Minsmere Levels Stakeholders Group Open Floor Hearing Transcript

Minsmere Levels Stakeholders Group main areas of concern regarding the Sizewell C development proposal are as follows. The Hard and Soft Coastal Defence, the Permanent and Temporary Beach Landing Facilities and impacts on the inland hydrology of both Sizewell Marsh and Minsmere South Levels as a result of the loss of Sizewell Marsh SSSI land, redirection of the Sizewell Drain, the SSSI Crossing and impacts of the borrow pits and spoil heaps.

DRAWING TITLE:
PERMANENT COASTAL DEFENCE FEATURE
TYPICAL SECTIONS (MAIN)

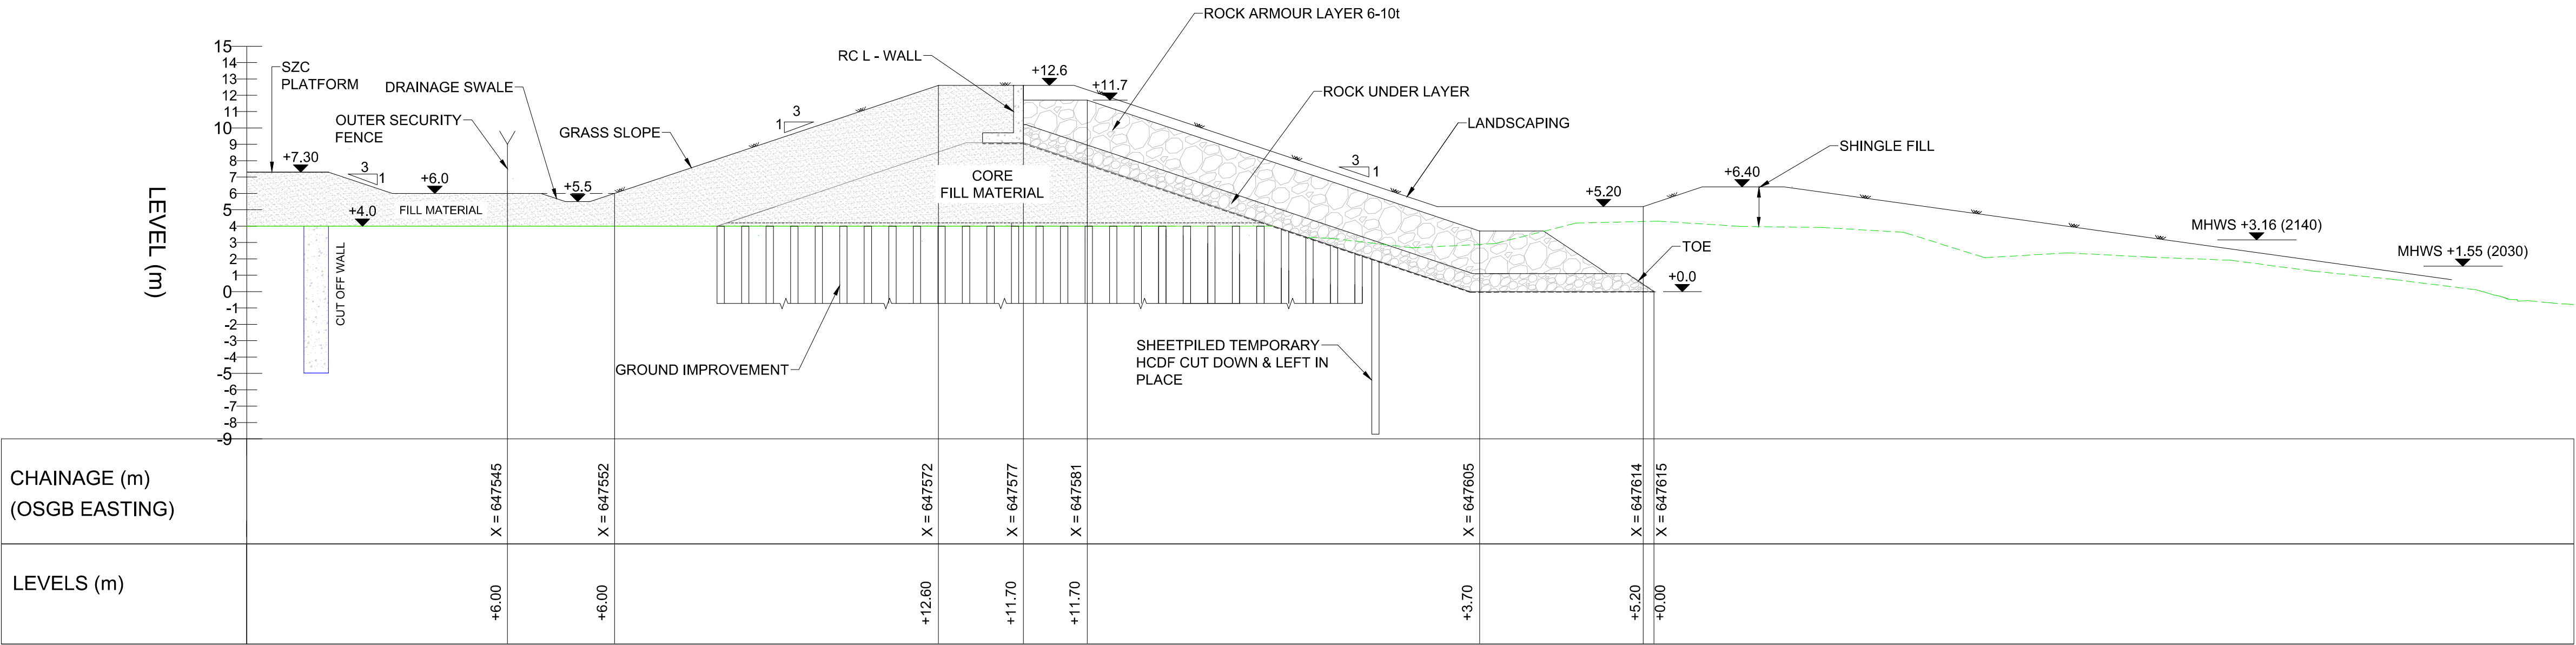
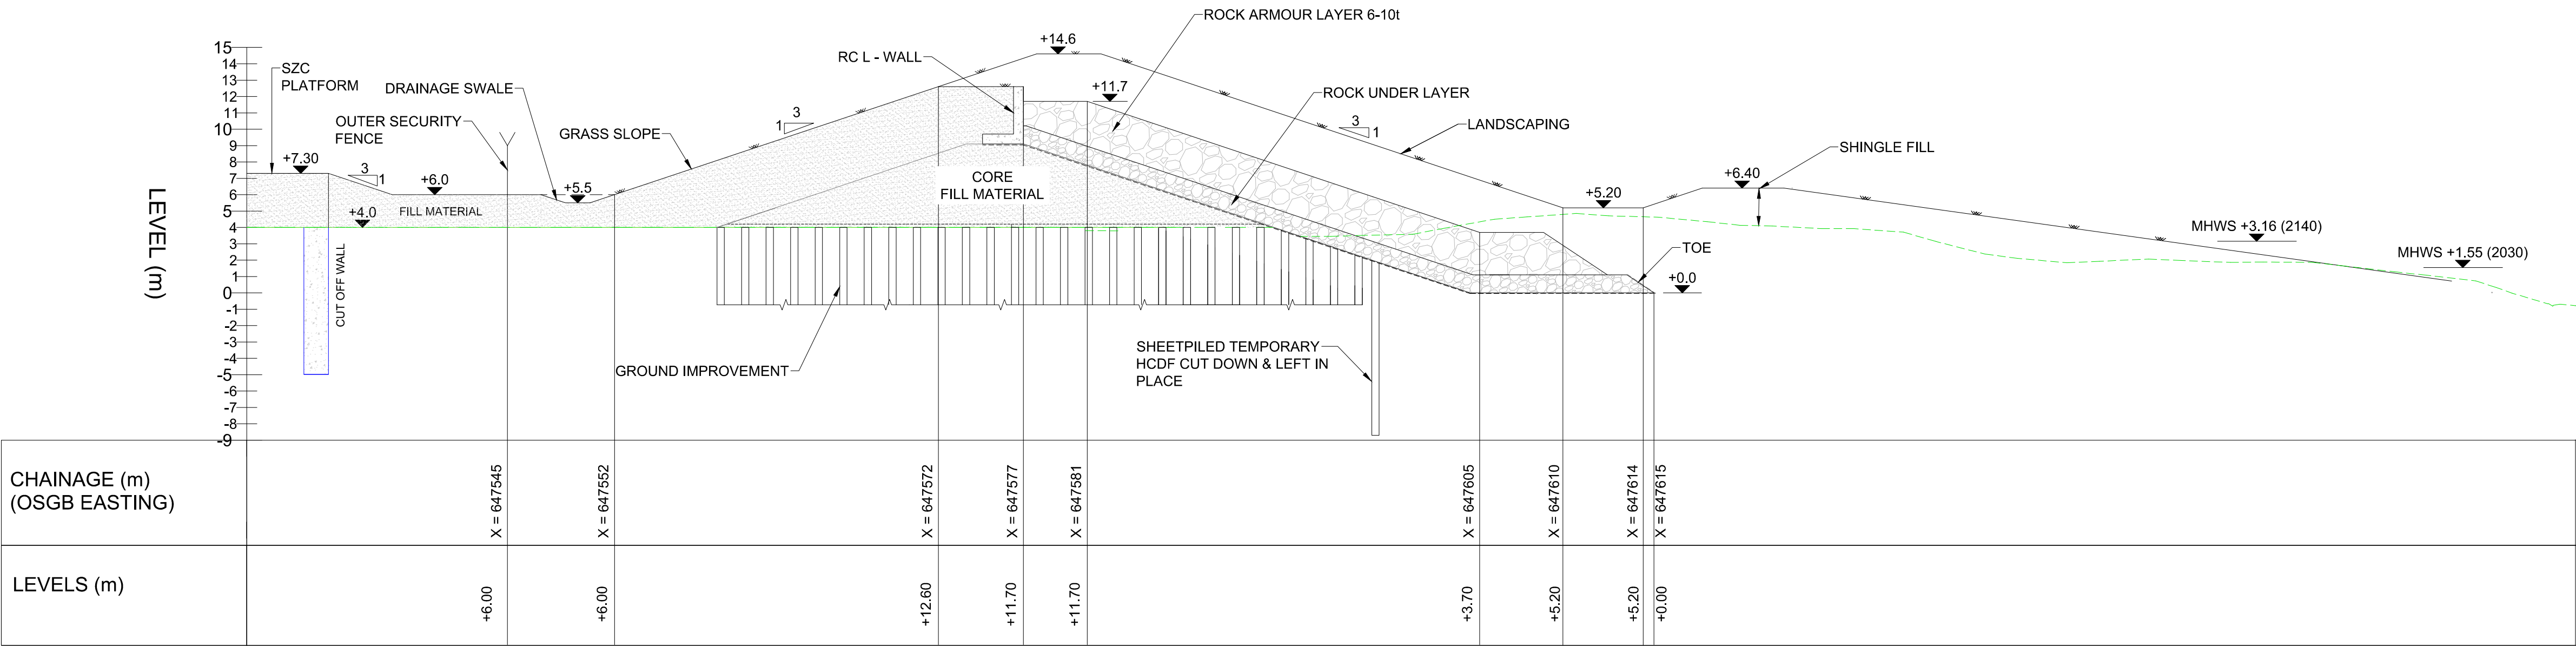
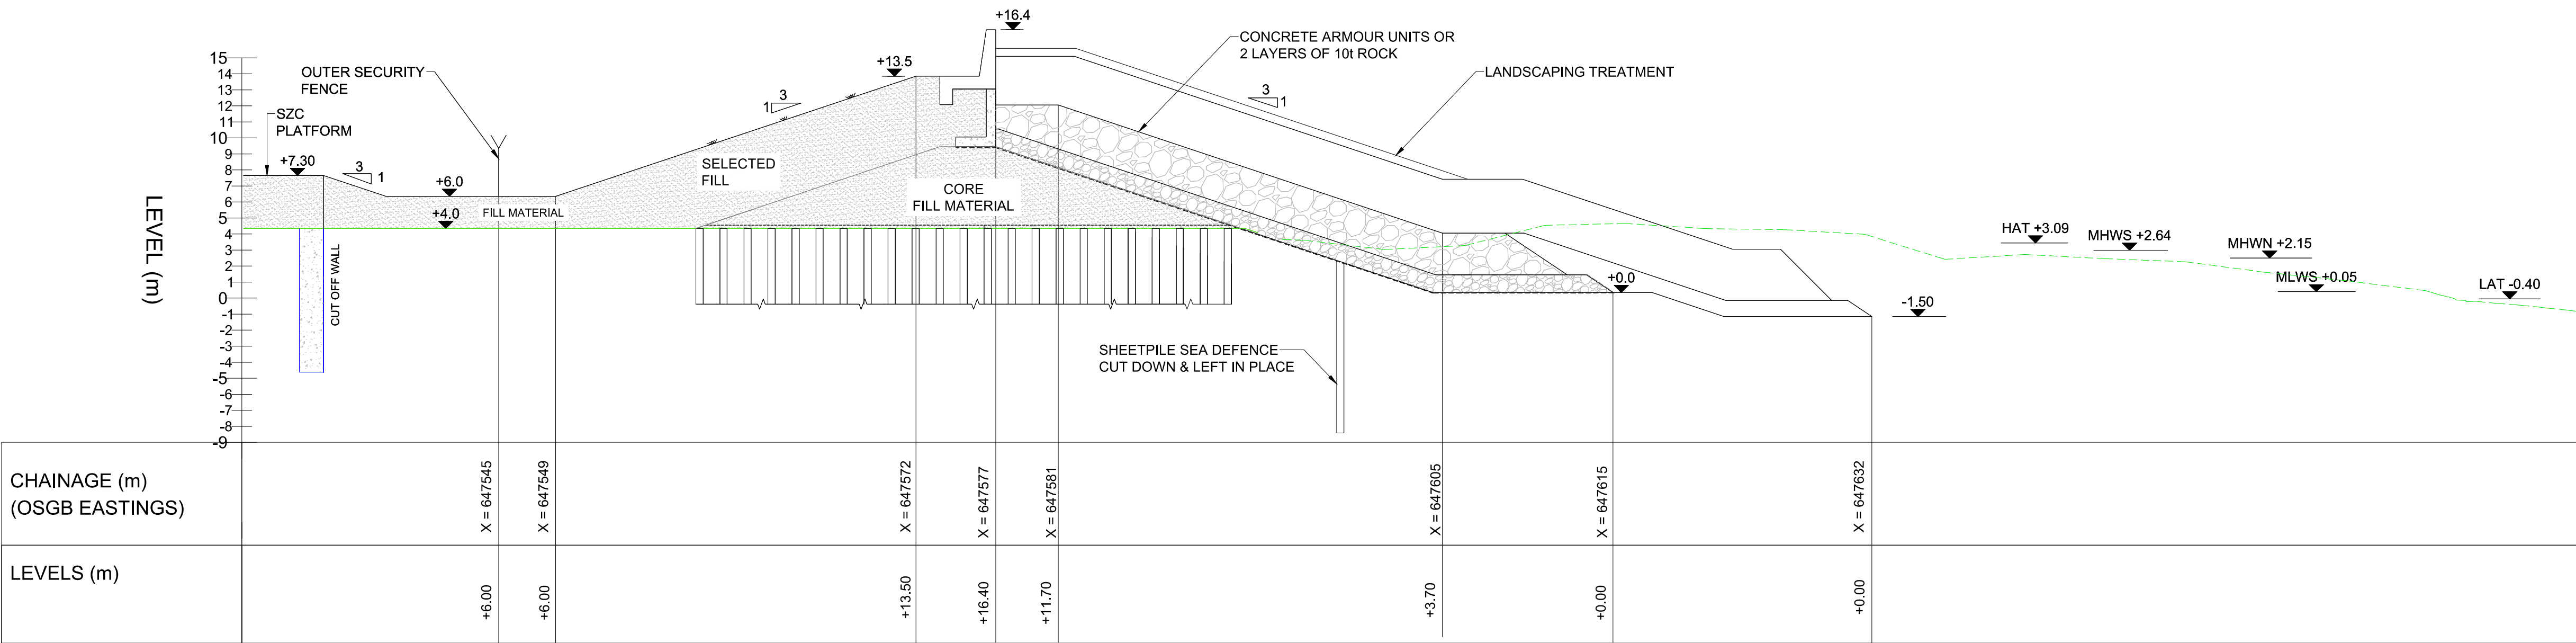
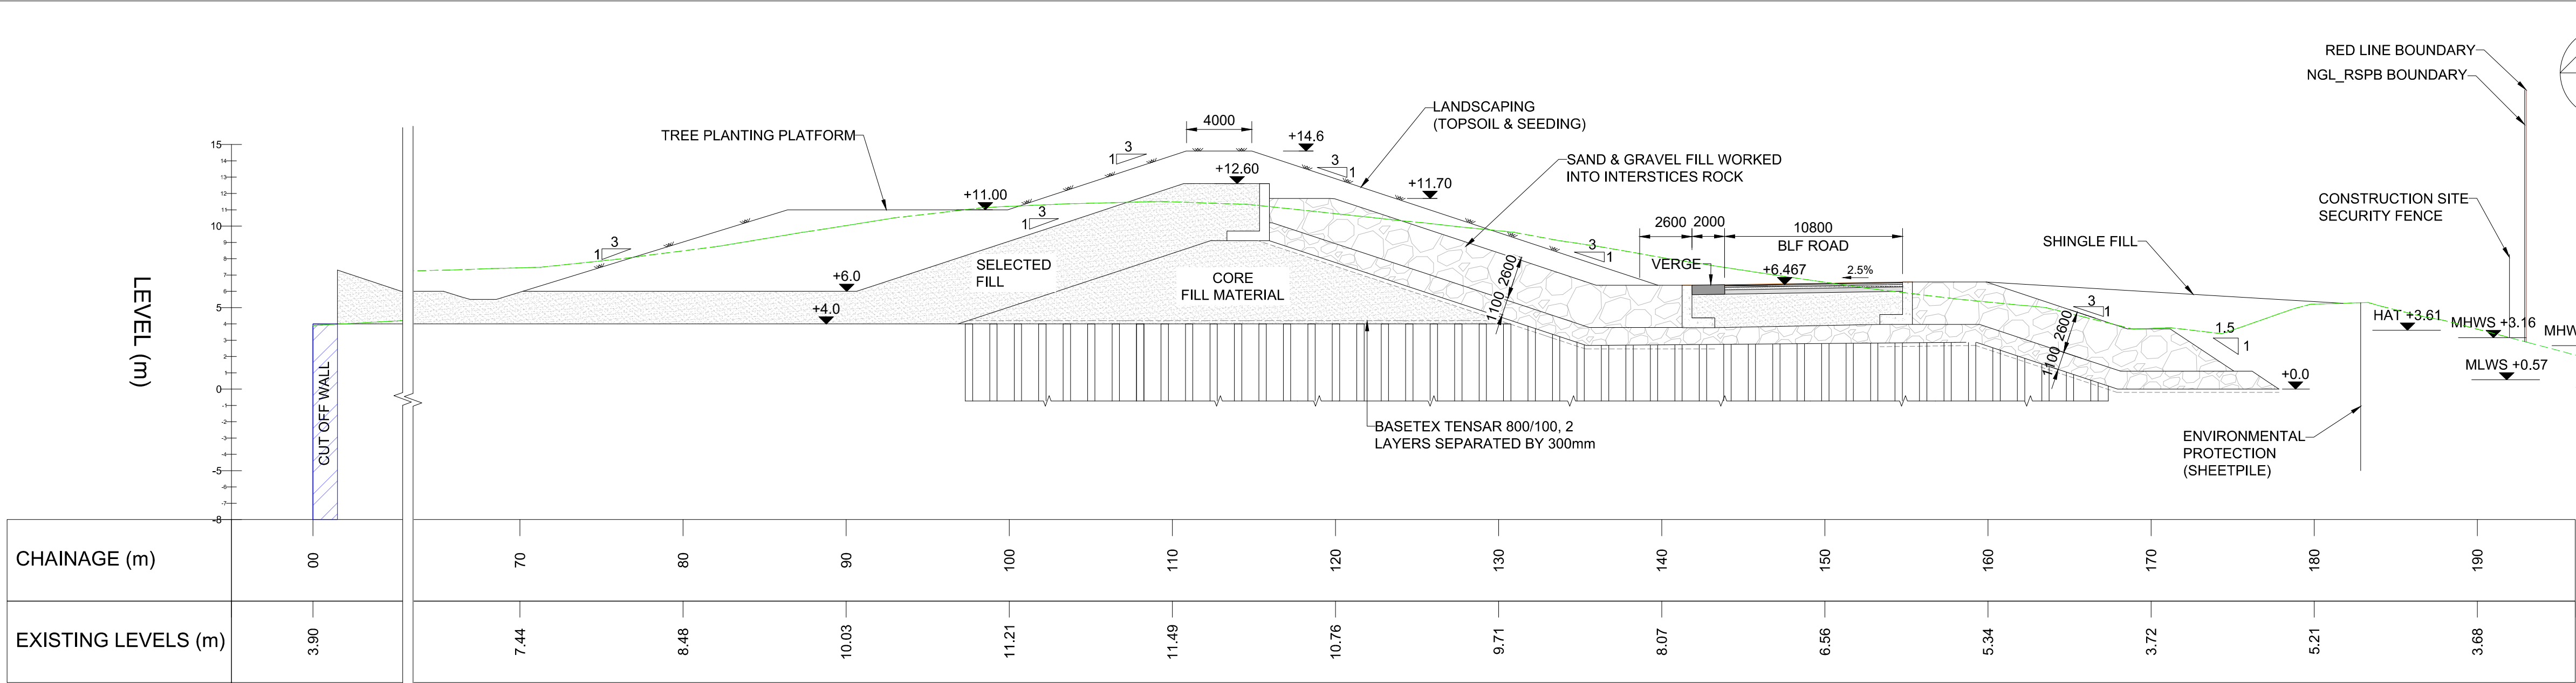
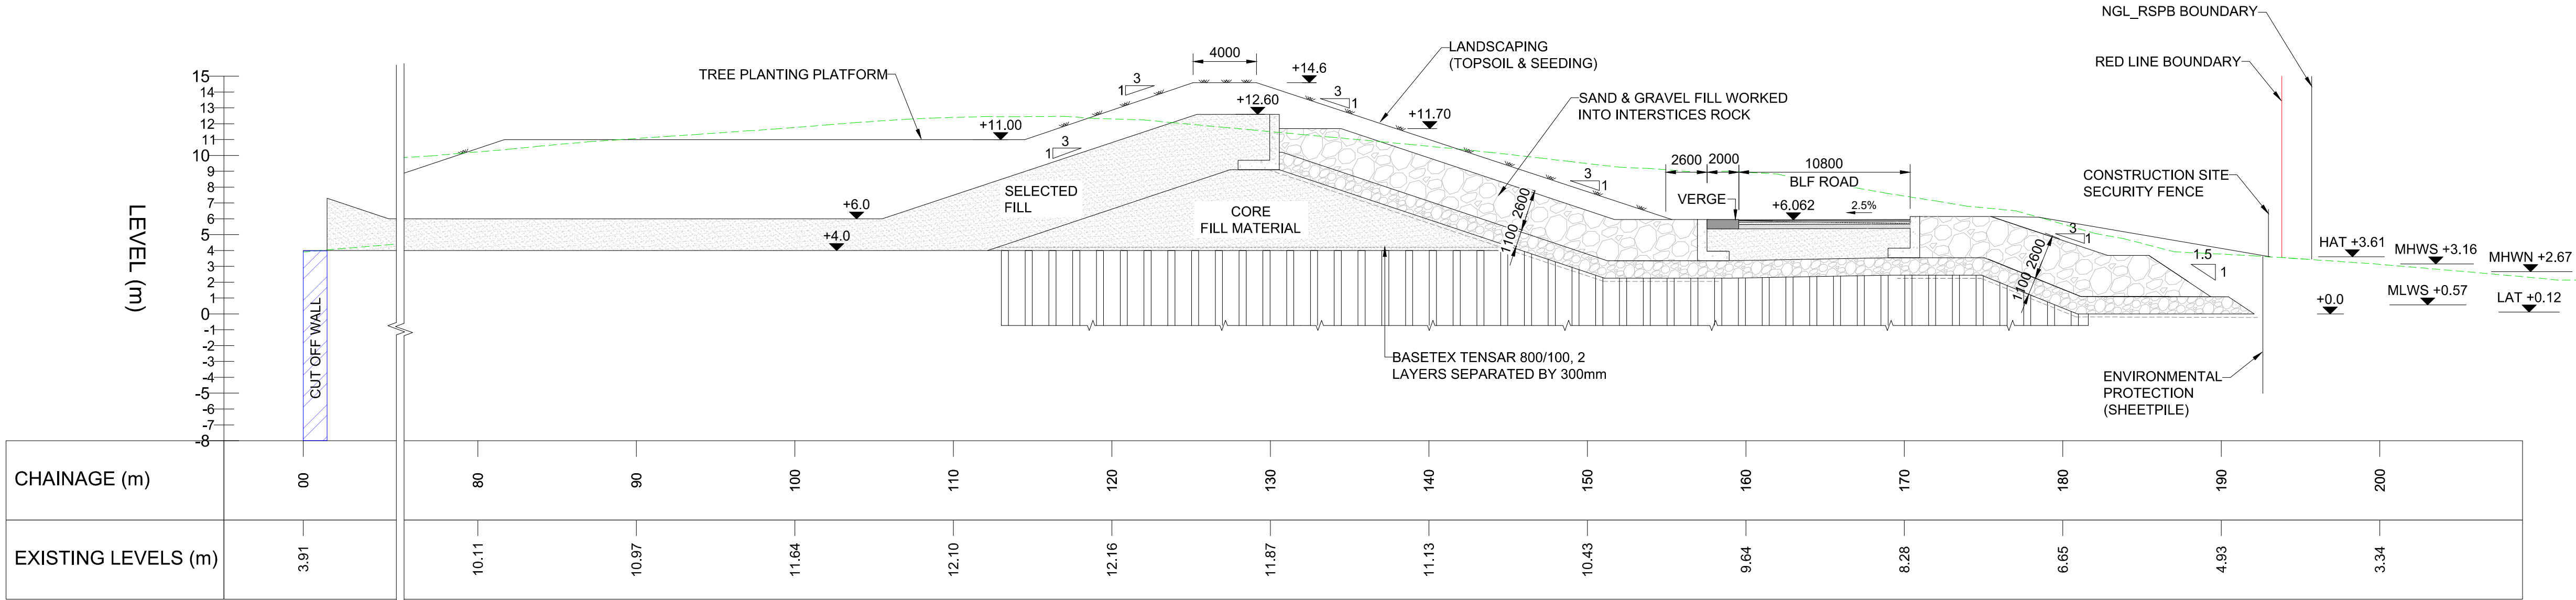
However, the three cross sections provided do not indicate where within the frontage these are located and there are inconsistencies between the figures with no consistent reference points to the cut-off wall, which is also the border between parameter zones C1 (cut-off wall) and C21 (HCDF/SCDF) ([AS-118](#)). One of the figures has no room to allow the adaptation increase in height of the HCDF and there is an inconsistency between figures regarding the toe of the adapted HCDF and statement 2.2.194 in the Environmental Statement Addendum ([AS-181](#)).

Whilst we await the detailed plans for the HCDF/SCDF at Deadline 2, we are concerned that unless cross-sections are given for the interface with SZB defences, the frontage at several locations and one through the reconstructed northern mound and BLF access roadway, a full evaluation will not be possible.

It is also unclear how the Hard Coastal Defence will incorporate and wrap round the access roadway given the position of the landward end of the BLF access roadway, the removable roadway and the piles and crossbeams progressing towards the barge mooring end of the structure 100m from the coast.

During consultations the slope of rock armour at the end of the permanent roadway was given as 1:4. In the plans referenced above, the roadway is given as being 5.435m AOD this will require about 22m of rock armour to reach 0m OD, the same level as the initial toe of the Hard Coastal Defence. This implies a significant incursion into the beach itself.
